26 November 2021

2190140

**RE: Response to Request for Information, Bays 1-4a of the Locomotive Workshop, South Eveleigh (SSD 8517, MOD 7)**

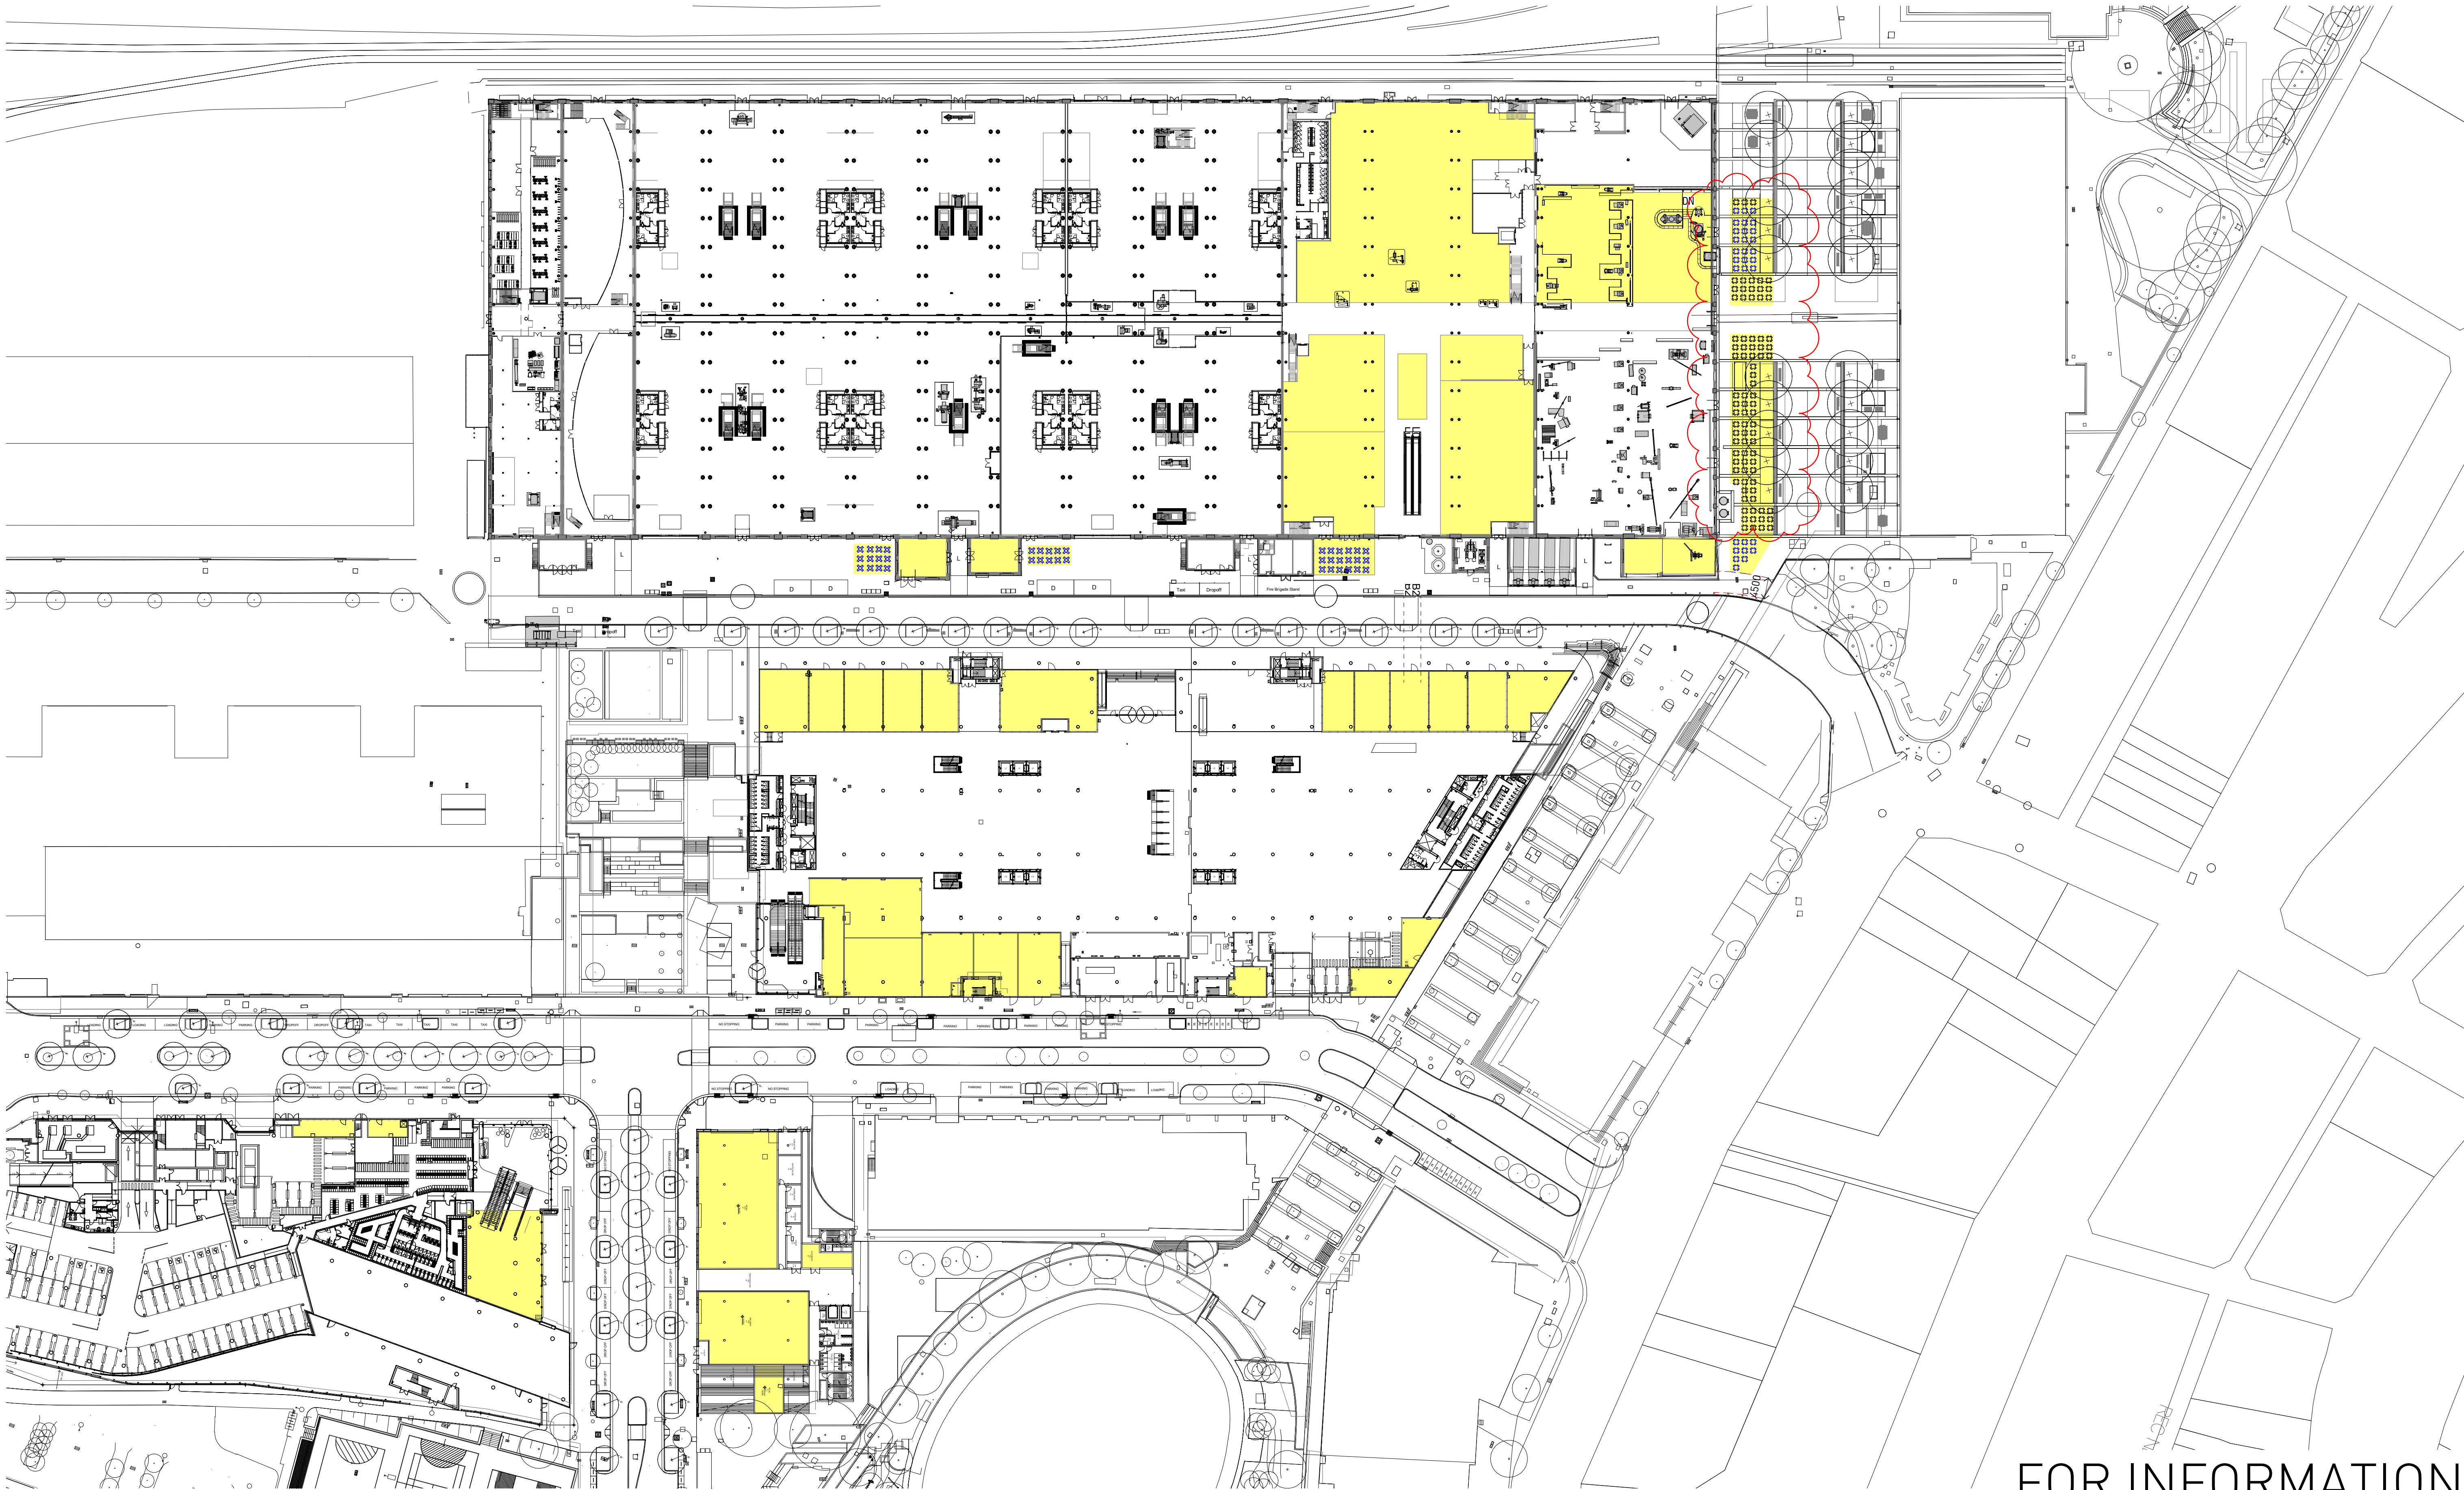
- Site Retail Plan, SA-AR-DWG-BB-B\$-0304, Rev U
- Proposed Plan – Ground Floor, SA-AR-DWG-BB-B4-0330, Rev DD
- Proposed Permanent Land Use Plan, SA-AR-DWG-BB-B4-0390, Rev M
- Proposed Area Plan – Innovation Plaza – Ground Floor, SA-AR-DWG-BB-B4-0395, Rev C
- SK\_096, Rev E. For this plan, please delineate and overlay the approved outdoor seating areas with the proposed expanded retail areas.

The Architectural Plans have been updated and are included at **Attachment A**. It is noted that the yellow shading has been extended cover the approved Bay 1 Annex southern seating area to provide consistency, but no change is proposed to what has previously been approved in this area. Notwithstanding this, a 4.5m clearway annotation has been inserted on the plans for clarity.
